RE: Planning Application 3/2017/0245

Barnsteads Barn, Waddington Road, West Bradford BB7 4SX

I write in my capacity as Clerk to West Bradford Parish Council. In their Council meeting on 29 March 2017, the Parish Councillors considered the above application and requested me to submit the following comments.

Proposed New Entrance Gates and Walls

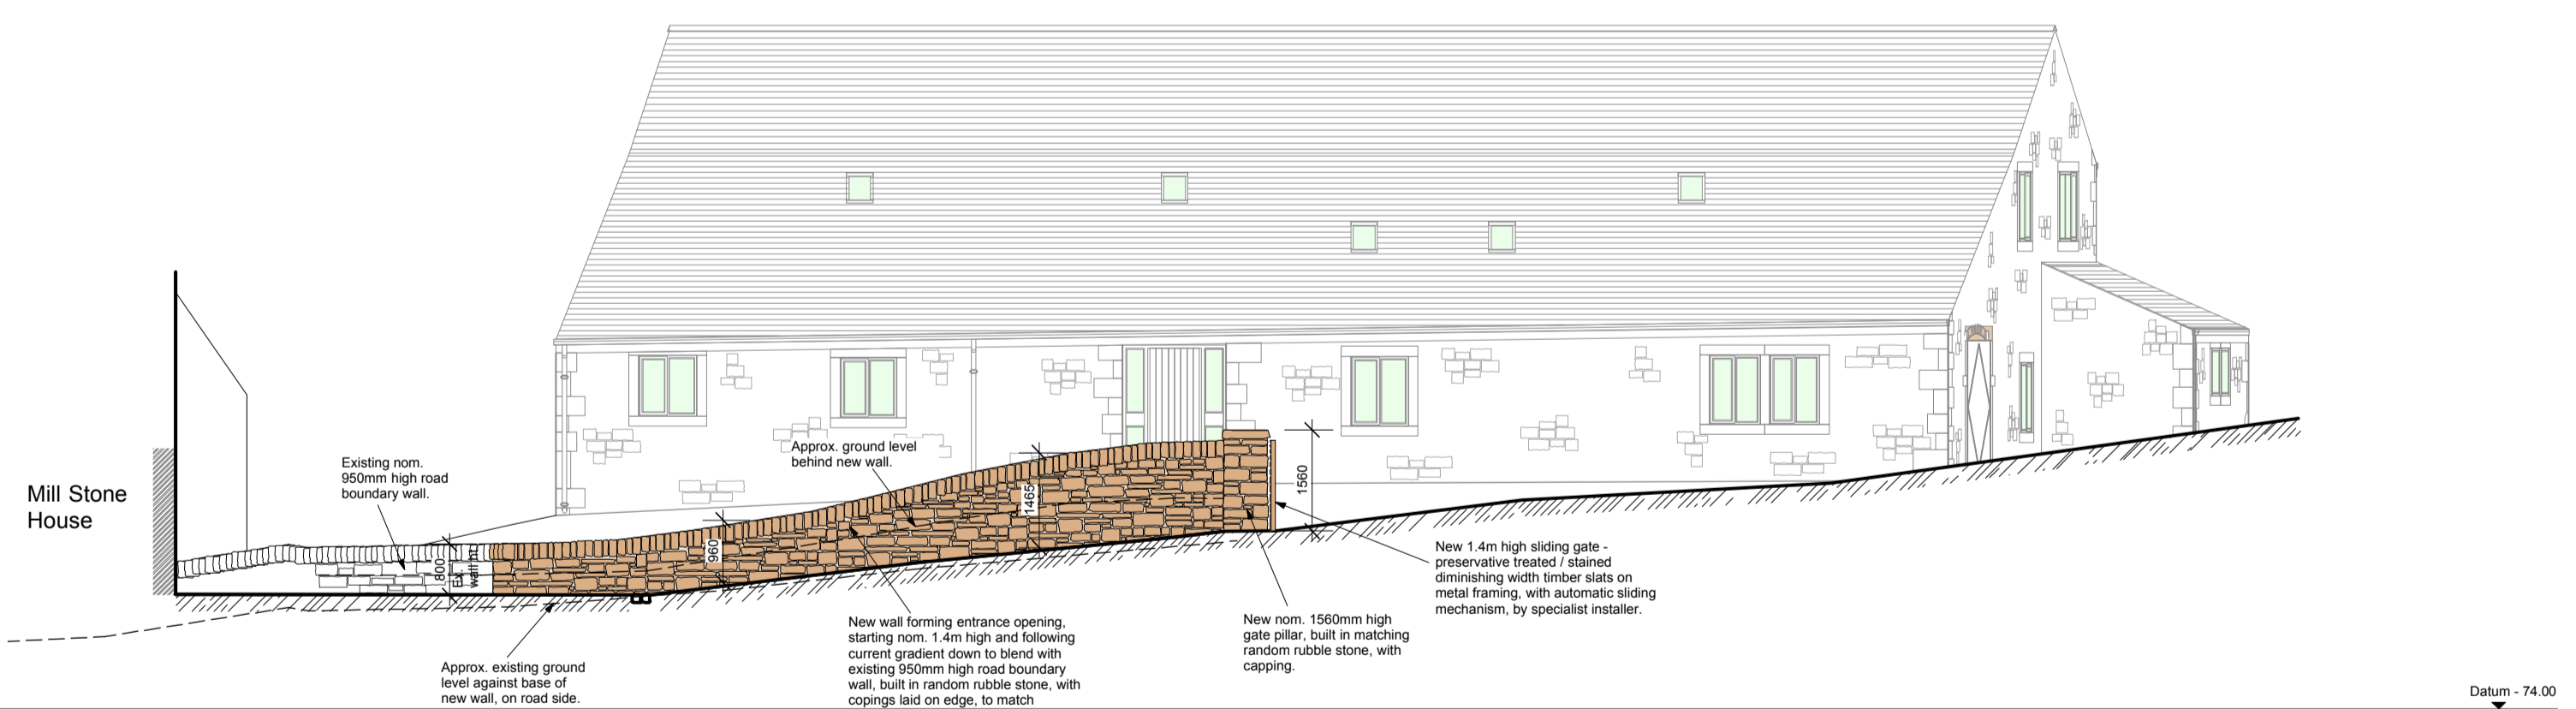
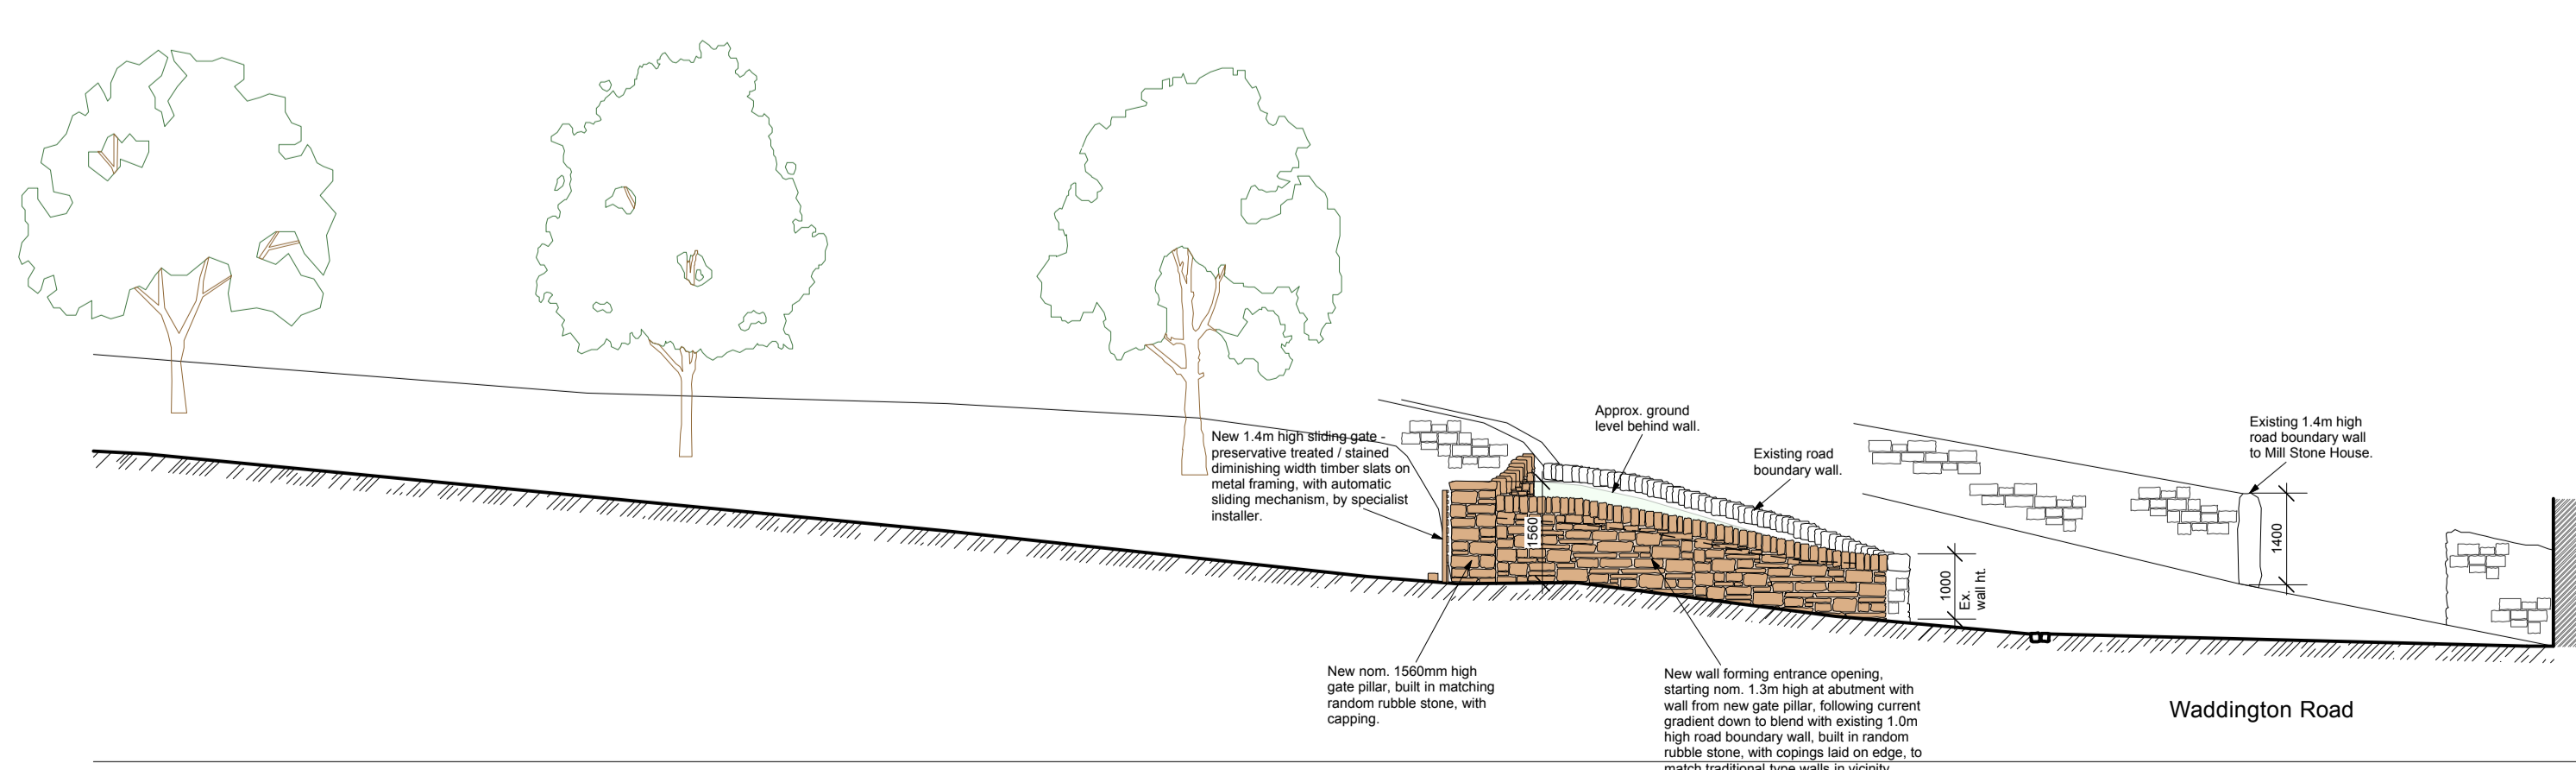
In the Parish Council's view, the proposed gate pillars at the entrance to the driveway should be considered too high at c1.56m. At this height, with their elevated location, the substantial construction of the gateway would give an overbearing appearance which is inconsistent with the location of the property (on the very fringe of the village with open aspects on the Waddington side). The proposed new gateway would be extremely prominent, falling within the sight line around the bend adjacent to the 3 Millstones restaurant. The proposed design for the driveway entrance would also be inconsistent with the overall appearance of West Bradford village. The Council noted the statement on the plans accompanying the application:

"New 1.4m high sliding gate, preservative treated stained diminishing width timber slats on metal framing, with automatic sliding mechanism, by specialist installer".

Again, such a design considered to be overly-dominant and go against the more open designs which generally prevail in the village and which the Parish Council wishes to encourage.
